12 June 2025

Subject: Request for Advice on Environmental Impact Statement – Residential development with infill affordable housing, 59-63 Trafalgar Avenue 1A and 1B Valley Road Lindfield (SSD-79276958) (Ku-ring-gai)

CPHR comments on the Environmental Impact Statement – Residential development with infill affordable housing, 59-63 Trafalgar Avenue 1A and 1B Valley Road Lindfield (SSD-79276958) (Ku-ring-gai)

Figure 36: Existing trees overlaid onto proposed site plan (Urban Arbor)

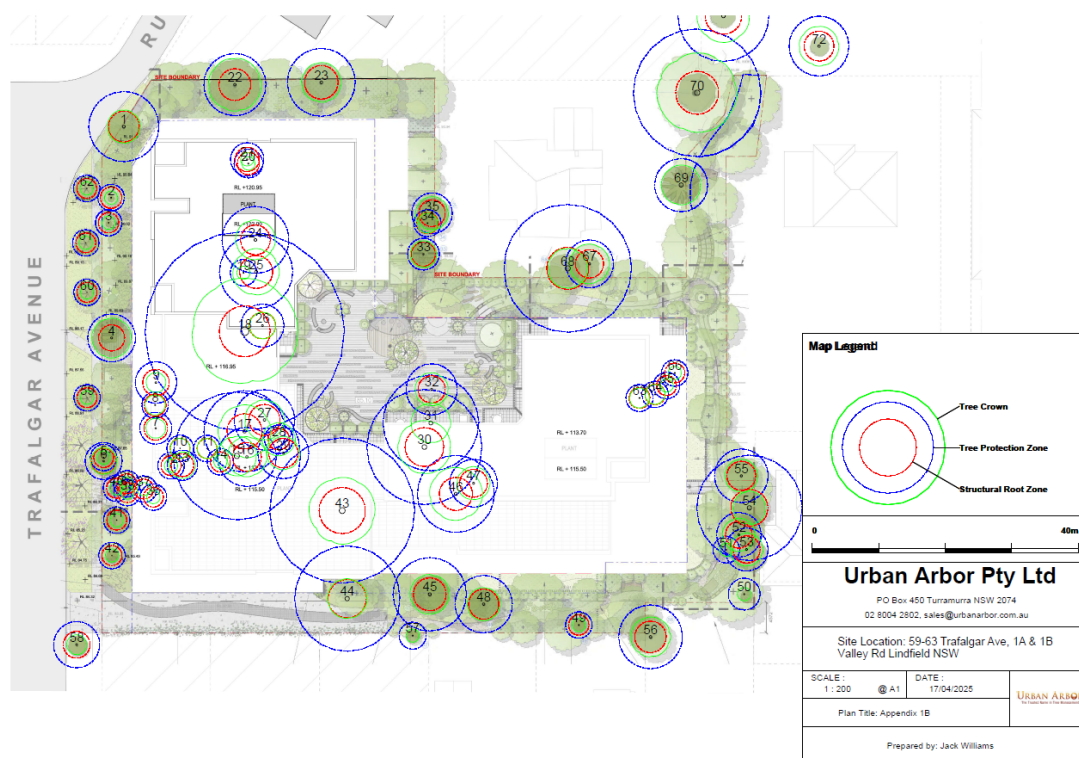
2.	Arborist report	There is insufficient evidence in the AIA regarding the viability of the trees to be retained. Trees 33, 34, 35, 45, 49, 52, 53, 54, 55, 58, 59, 60, 61, 62, 69, 70 have limited biodiversity value, though some may possess landscape significance. The removal or retention of these trees would not materially affect the Biodiversity Development Assessment Report (BDAR). As such, CPHR does not need to review any updated AIA. CPHR has identified the following concerns regarding the submitted Arboricultural Impact Assessment (AIA): • The AIA nominates several trees for retention but does not demonstrate how these trees can be viably retained. • The AIA refers to the need for root mapping to assess the viability of tree retention and the construction of hardstand without significant root impacts. • The proposed stormwater infrastructure, particularly the 60 m stormwater line along Trafalgar Avenue, has not been considered in relation to tree impacts, including street trees. • The AIA does not demonstrate how neighbouring trees can be viably retained. Recommended actions: • DPHI should determine the viability of tree retention prior to development consent, in accordance with Section 3.3.3 of Australian Standard AS 4970–2009, which requires the AIA to demonstrate viable retention of trees. This is also consistent

with the SEARS requirement for root mapping, which should be undertaken prior to determination to confirm which trees can be viably retained. • The AIA should clearly demonstrate the application of tree-sensitive construction methods to ensure viable retention, including updated and/or annotated plans prepared in consultation with the project arborist. • DPHI to consider requesting an updated AIA that clearly demonstrates how nominated trees will be viably retained. • DPHI to consider imposing consent conditions, including: ○ supervision and certification by an AQF Level 5 arborist in accordance with AS 4970–2009. ○ the implementation of the mitigation measures outlined in section 8 of the BDAR. ○ the protection of trees identified for retention in an updated AIA.
	<i>Extent and Timing</i>	Pre-determination
